Application No: P/70/22/DOC
Registered: 29th April 2022
Site Address: Land adjacent to Sefter School House Sefter Road Pagham
Grid Reference: 489528 99491
Category: Discharge of Condi
Description of Works: Approval of details reserved by condition imposed under P/116/19/OUT relating to conditions 9-surface water drainage, 10-discharge of flows to watercourses & 11-maintenance and management of surface water drainage.

PURECON_DOC (005) 0020

Planning Reference: P/70/22/DOC

Approval of details reserved by condition imposed under P/116/19/OUT relating to conditions 9-surface water drainage, 10-discharge of flows to watercourses & 11-maintenance and management of surface water drainage.

Below Ground Drainage Layout

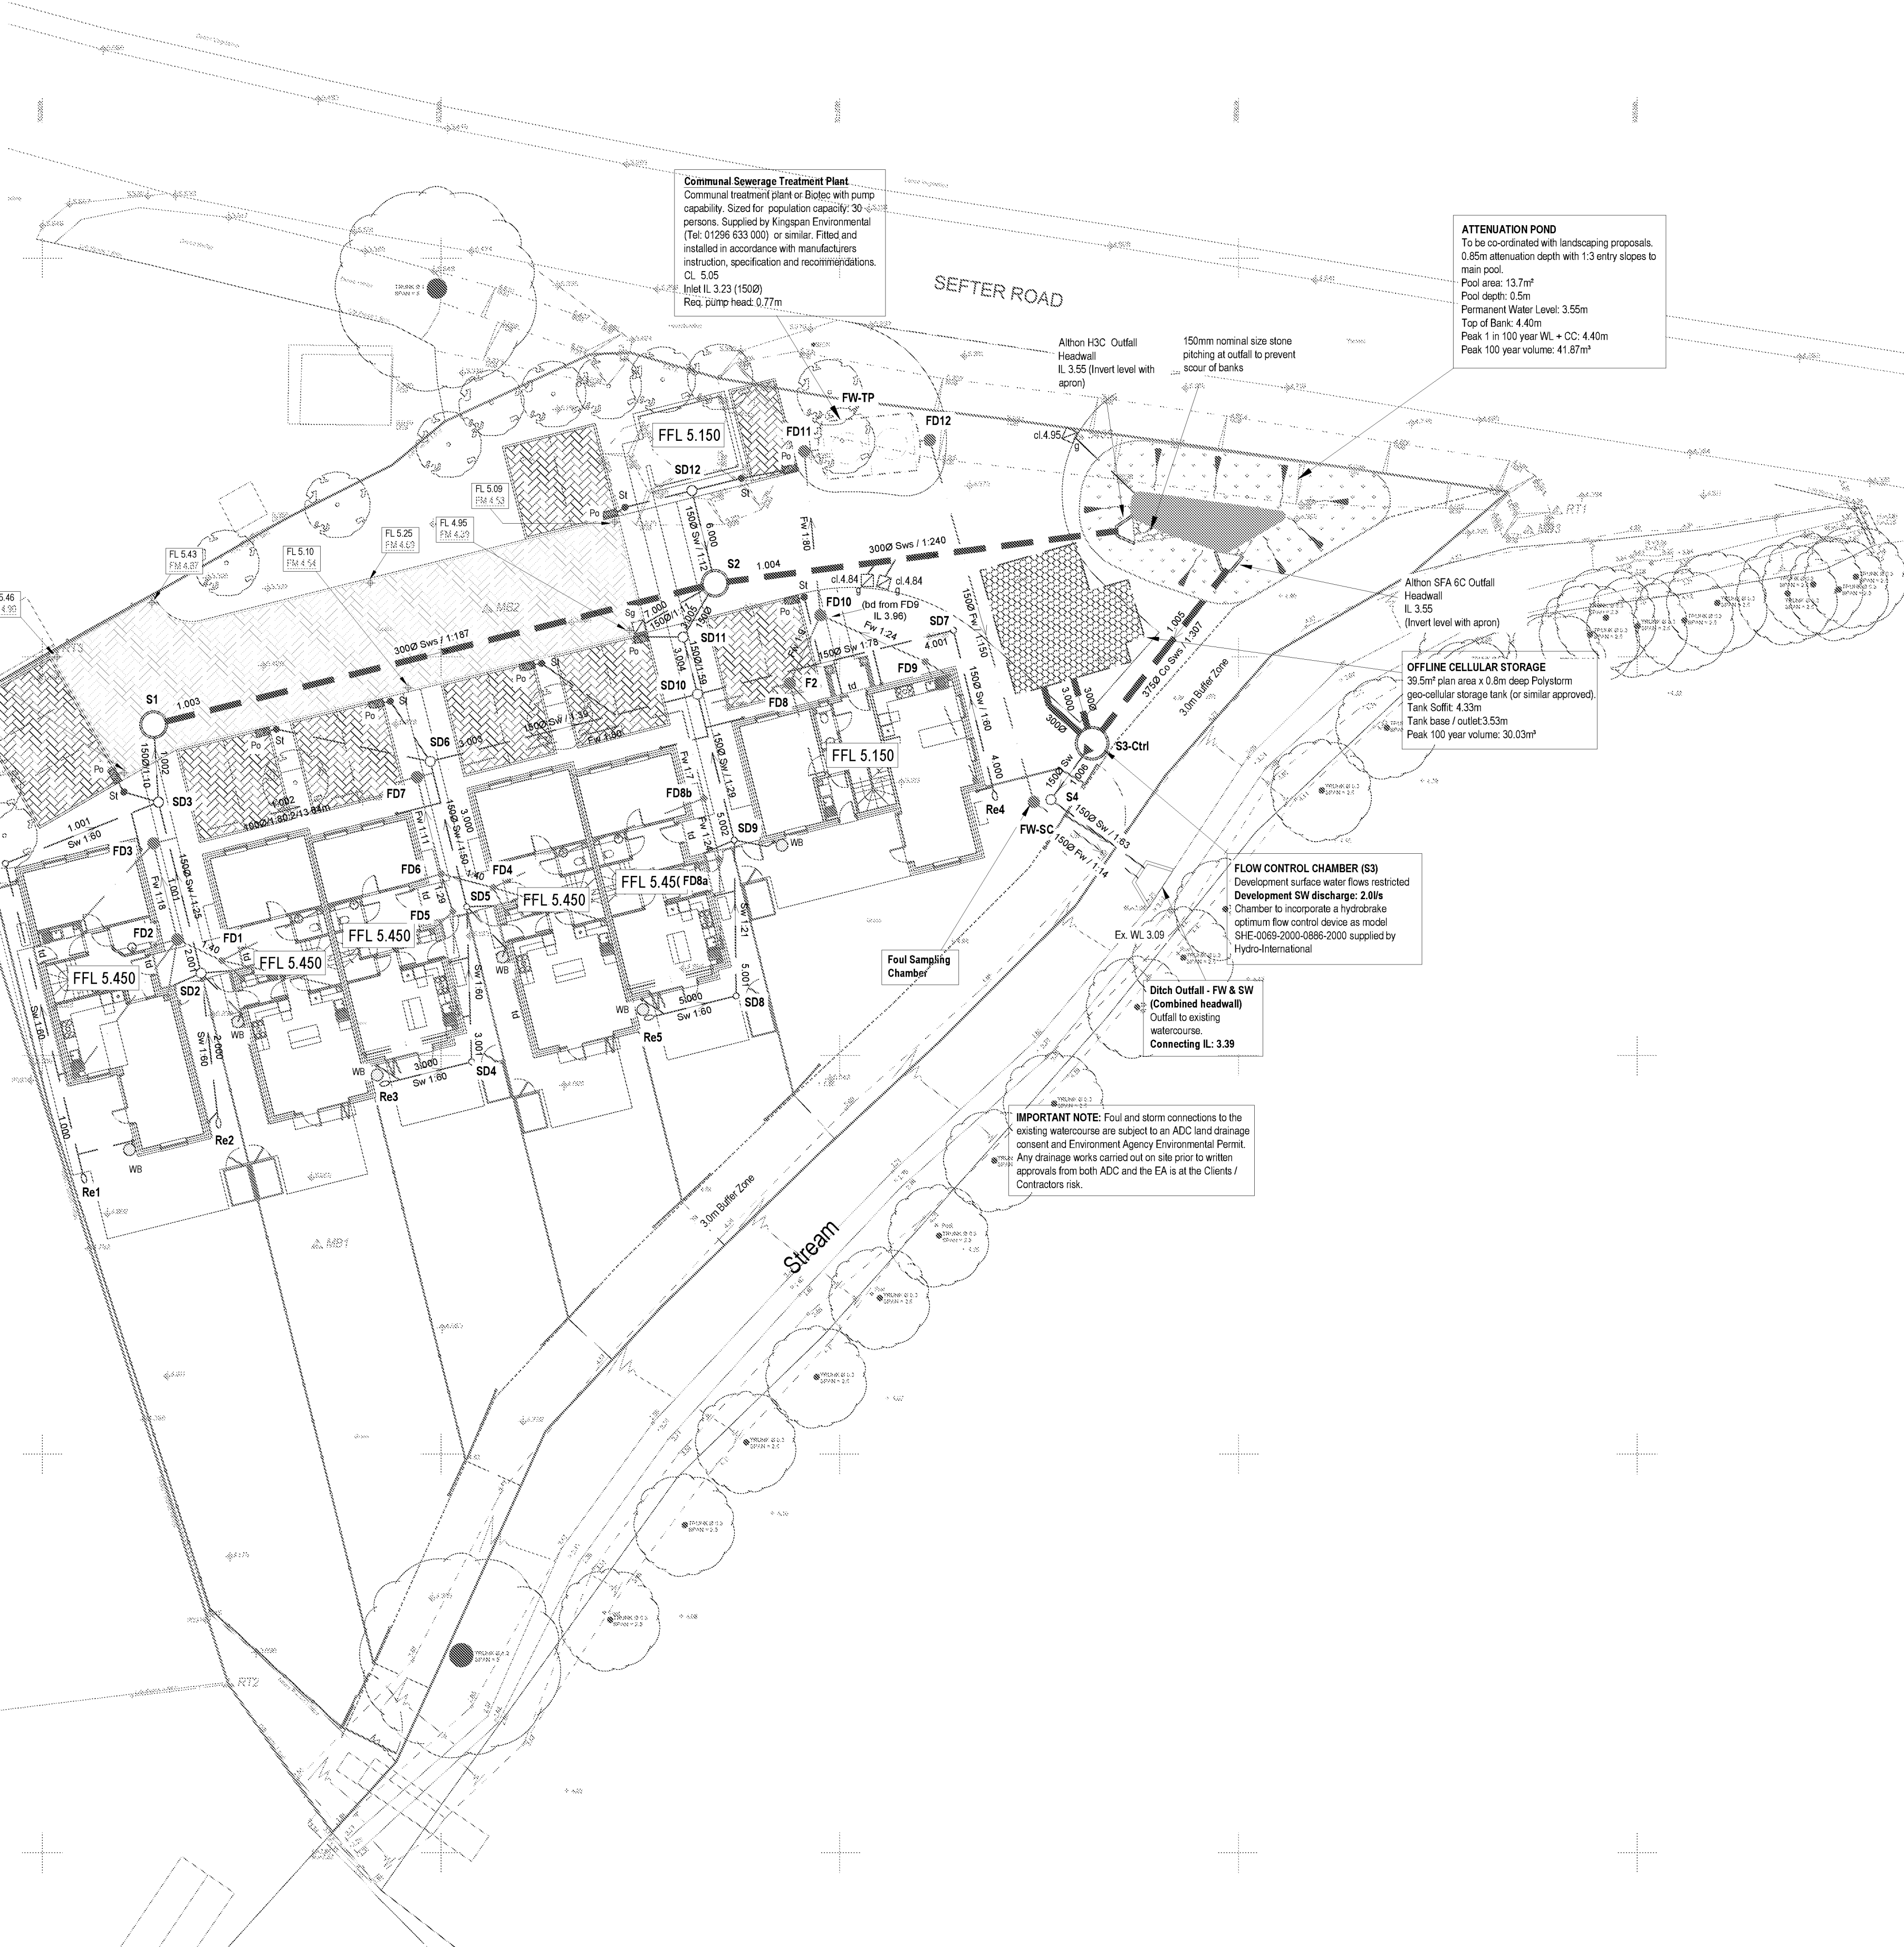
The proposed construction of the attenuation basin and associated earthworks appear to extend beyond the redline planning boundary. This should be reviewed to ensure works do not fall outside approved planning boundary or site land ownership.

Manhole S2, should be a catchpit. A catch pit manhole is required upstream of attenuation basin to provide sediment control.

Polystorm Attenuation Tank - Plan View

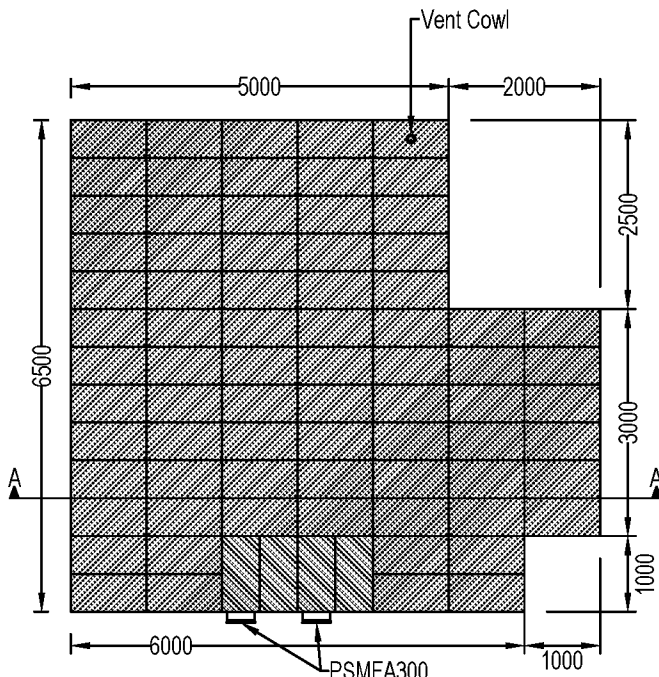
Bouyancy calculations indicate that the current arrangement in relation to the polystorm attenuation tank will fail without additional measures in place to counter the uplift forces. The design needs to be reviewed and additional mitigation measures added to the design to counter the effects of buoyancy

Typical Cross Section Through Permeable Block Paved Parking Bay Adjacent Tarmac Construction (1:20)

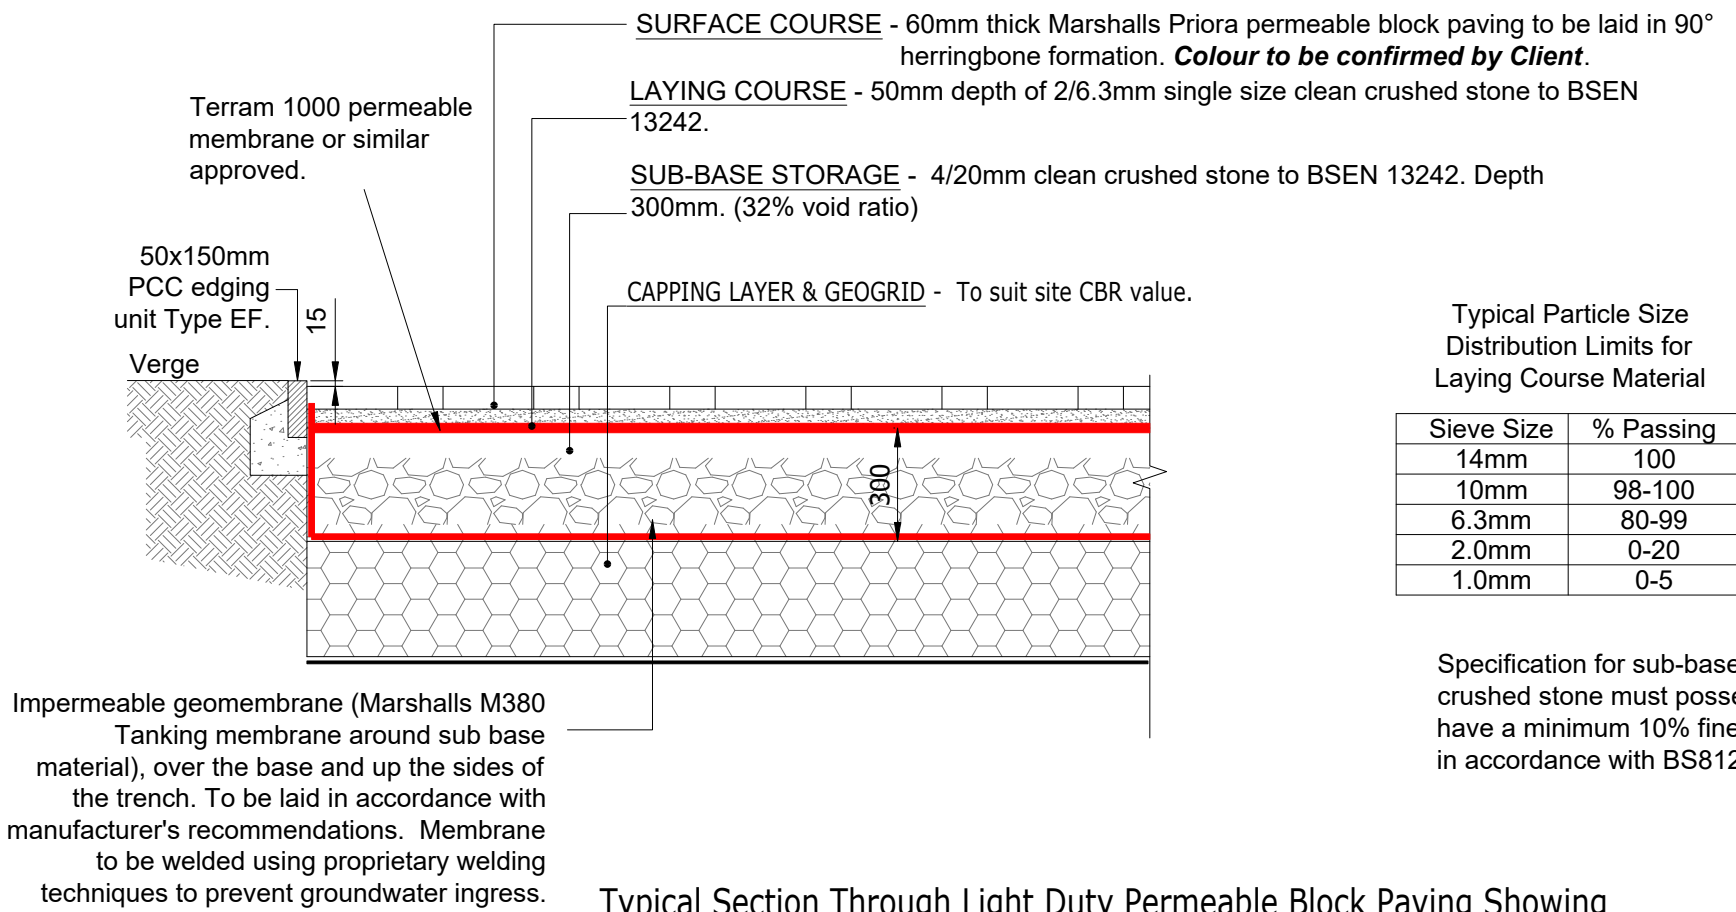
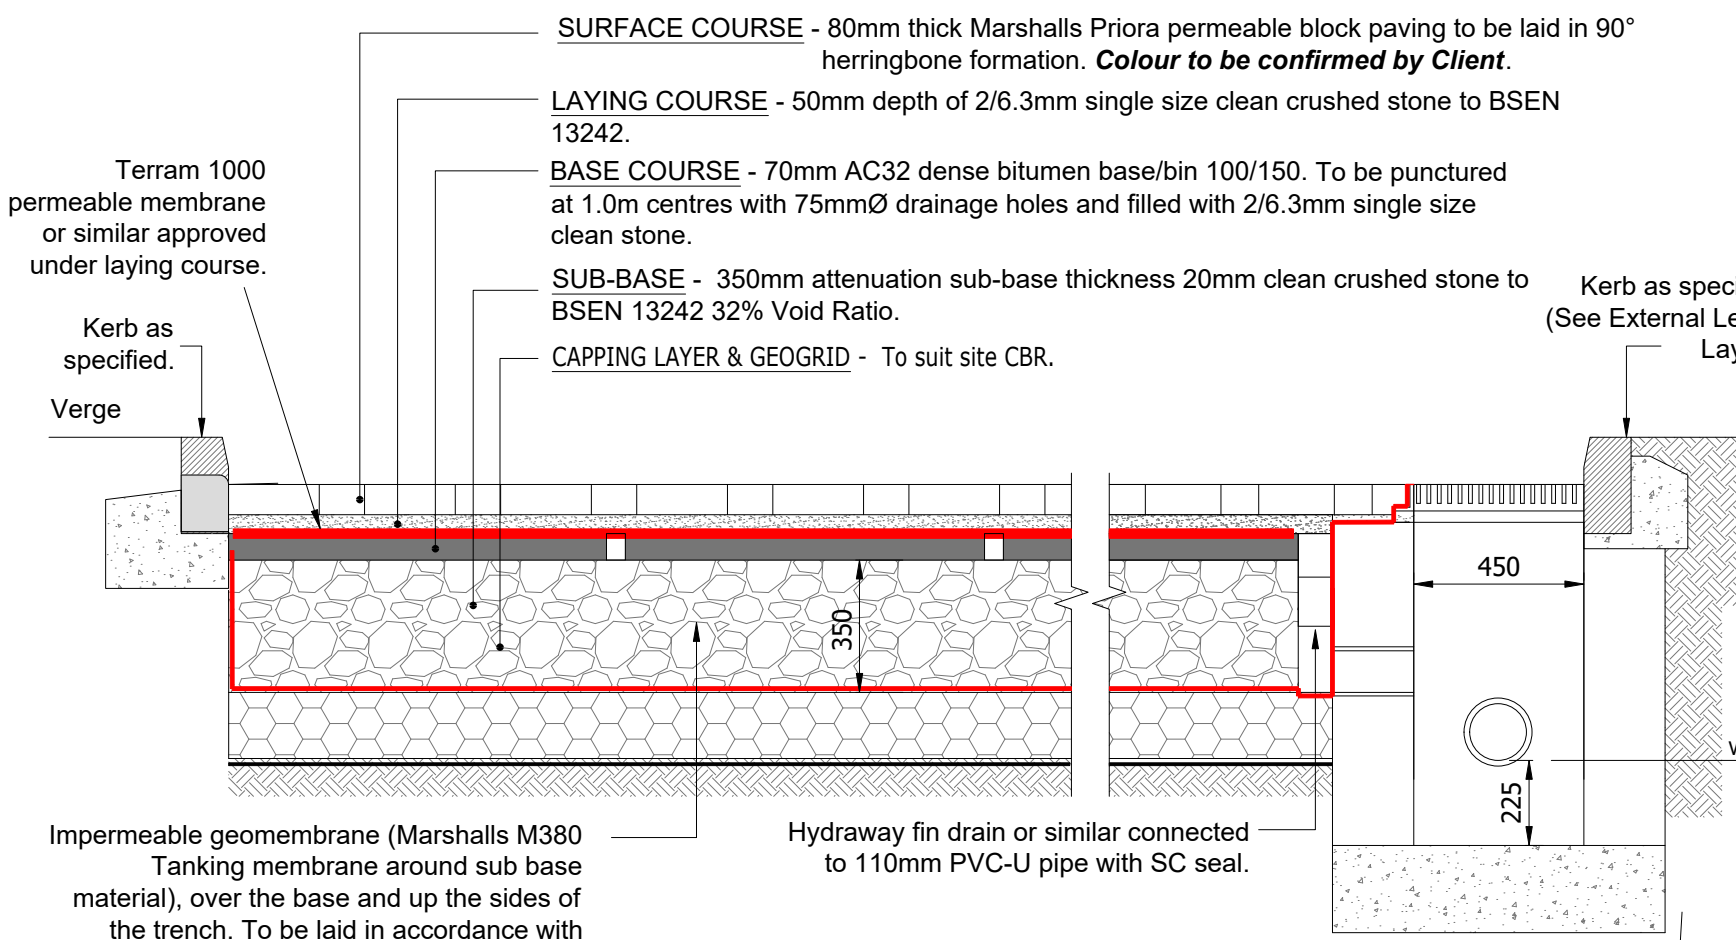
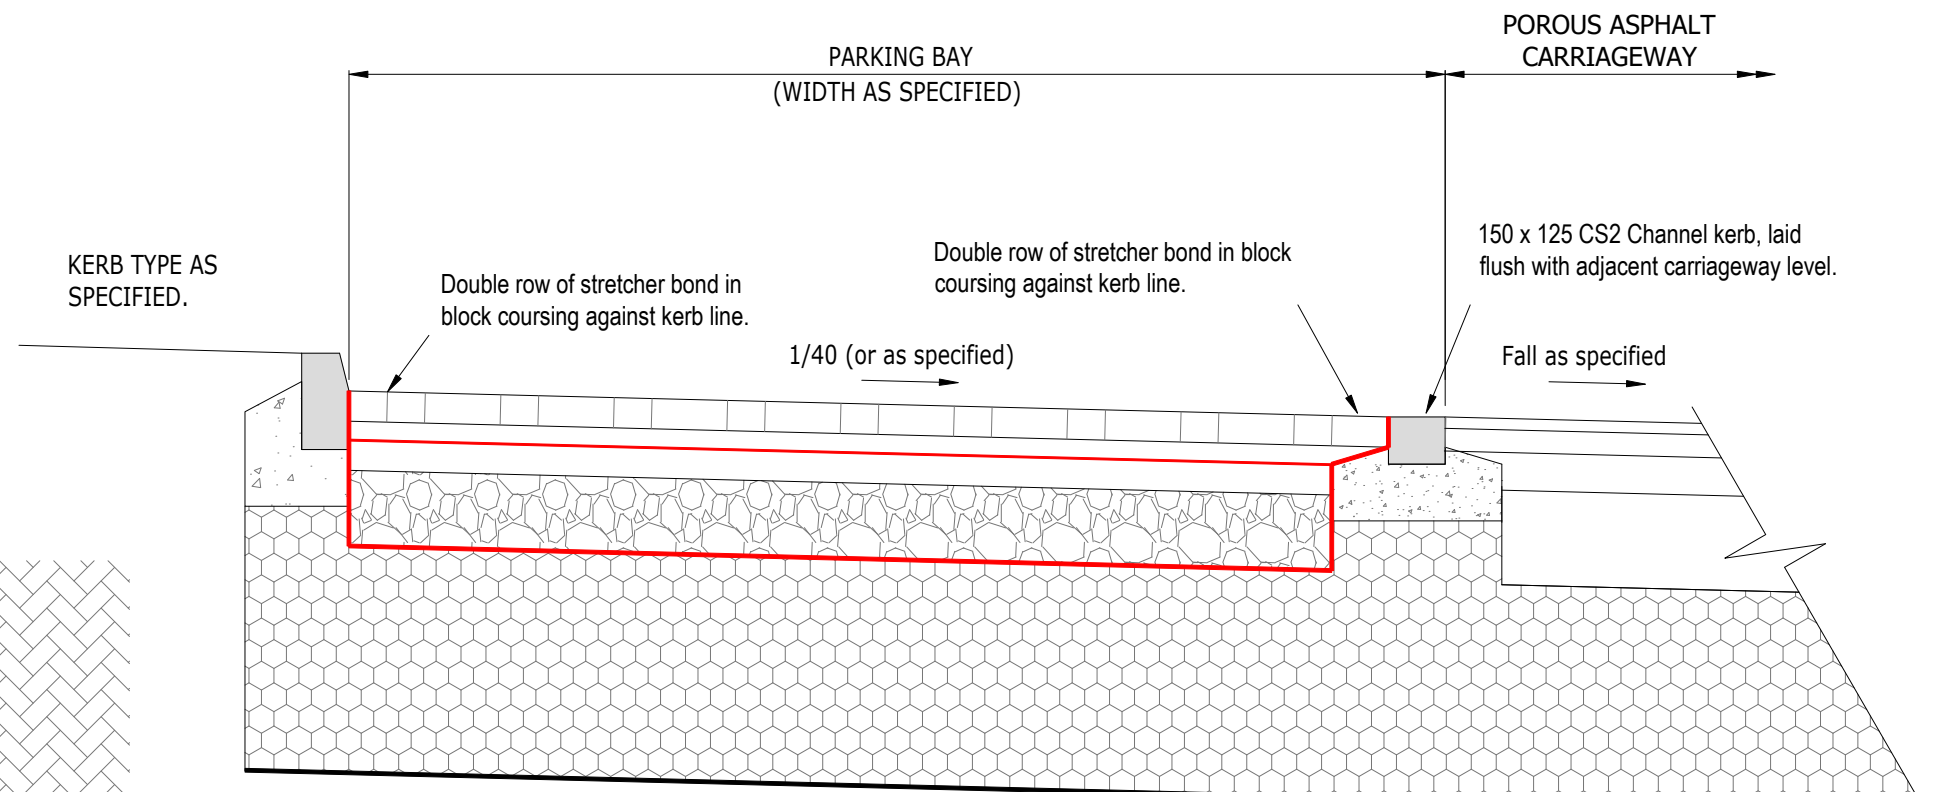
Formation levels information is required for the permeable paving bays as well
